Application H09-0430-16
Location Land off Penny Hill Road Holbeach Spalding
Proposal Residential development of 44 dwellings

Name Angela Doherty
Address Housing Strategy

Date Submitted 21-06-16
For/Against Comments

Site Layout 1:500

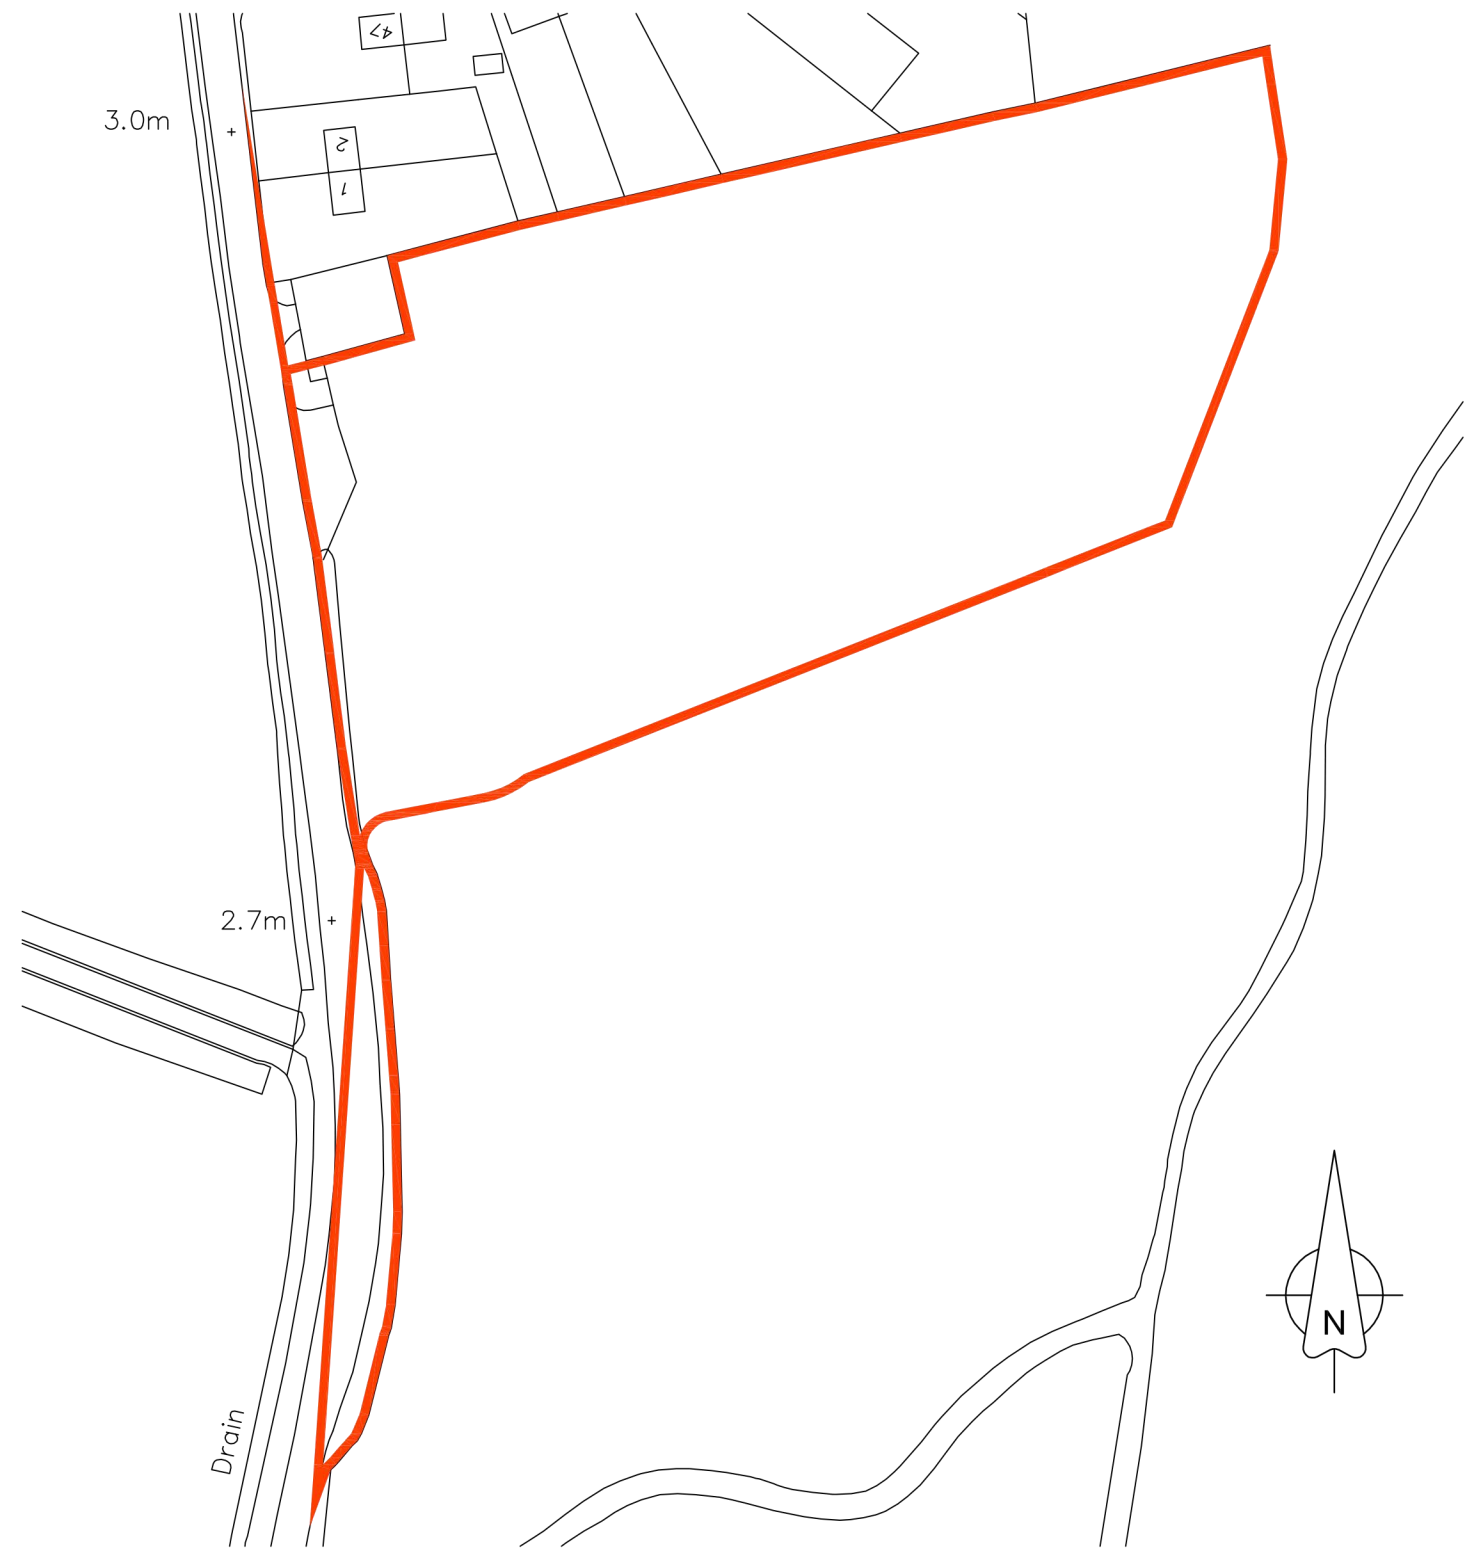
The proposals also include for the affordable rent units to all be one bedroom units, the council would prefer for there to be a mix of one and two bedroom units for rent.

Ideally the affordable housing should be spread proportionately across the scheme to enable a mixed and sustainable community.
